CITY OF MERCER ISLAND

December 26, 2017

Re: Preliminary Approval Decision Letter for SUB17-006 and SUB17-007
Lot Line Consolidation and Plat Alteration located at 7840 and 8000 SE 20th ST Mercer Island,
WA 98040; Parcel ID's: 5452302218 and 5452302216.

PRELIMINARY
NFH RESIDENCE LOT LINE REVISION
(LOT CONSOLIDATION)
POR. OF GOV. LOT 1, SEC. 1, TWP. 24 N., RGE. 4 E., W.M.

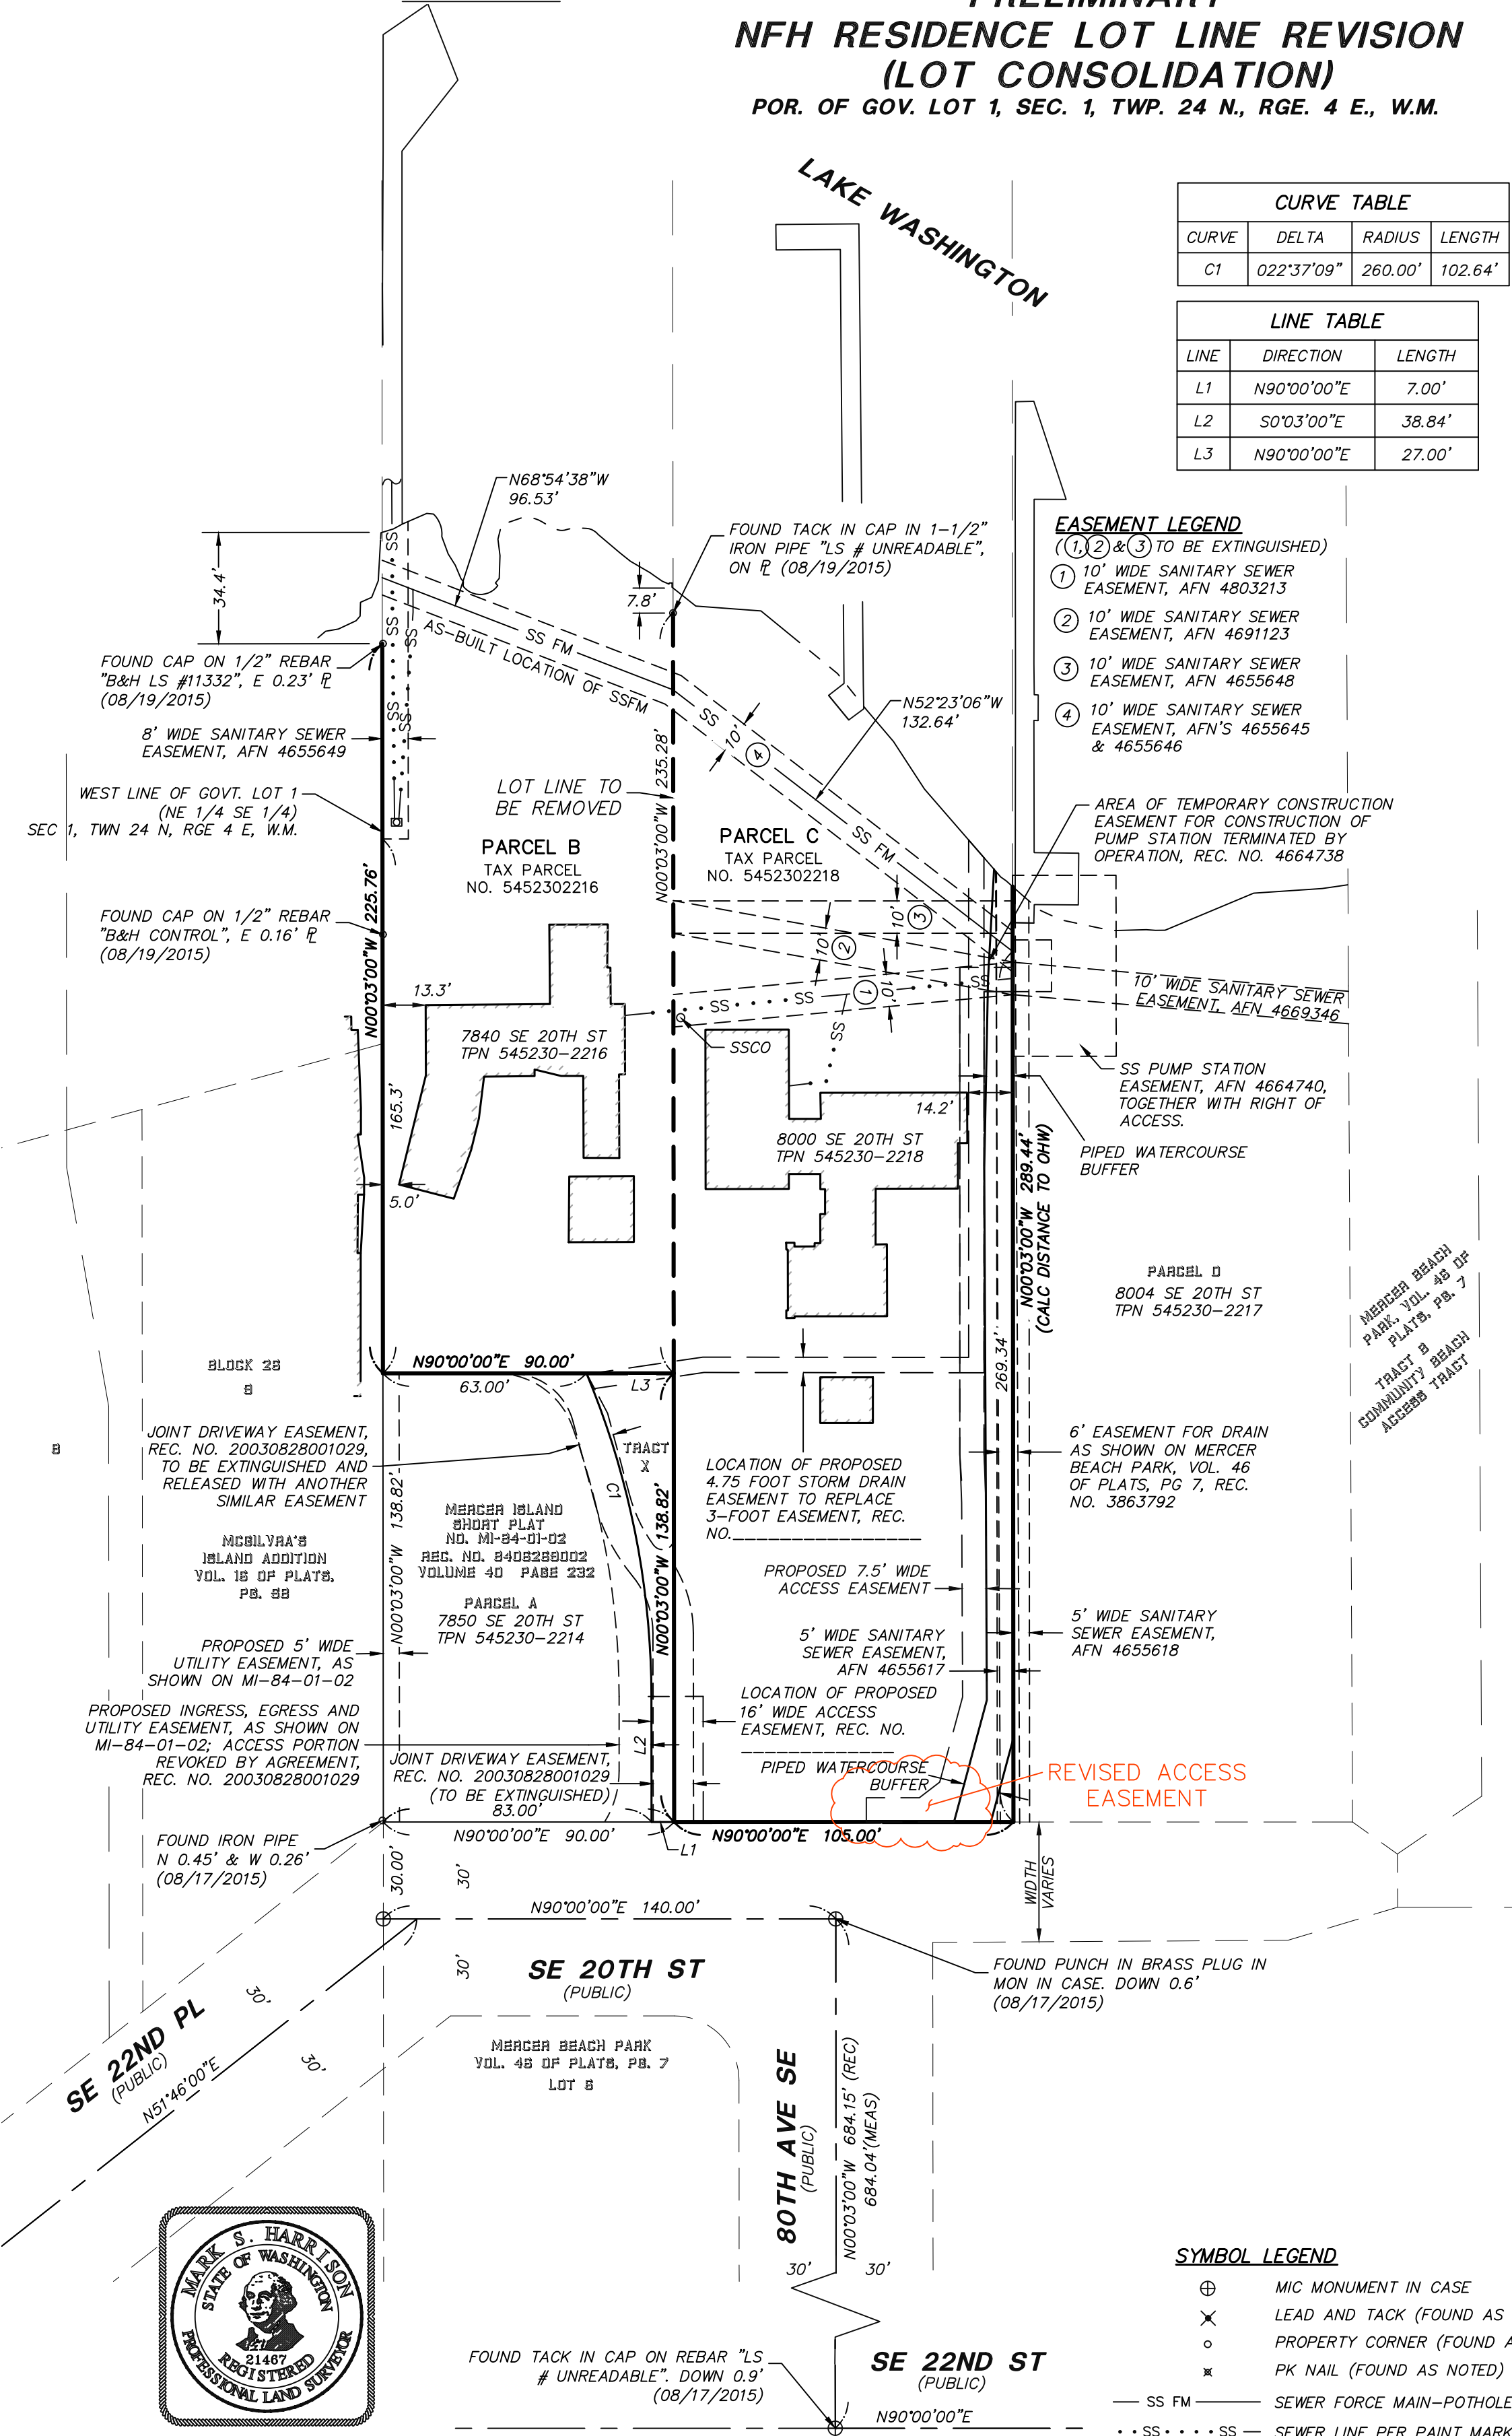
2. Plans provided for final plat approval shall show all the existing and proposed easements on the final plat. The plans shall also clearly distinguish all public easements from the private easements. The private utility easement and public utility easement shall not be combined. All recording numbers must be shown on the final plat.
3. Plans submitted for final plat shall use Mercer Island's datum and tie the plat to at least two known City monuments.
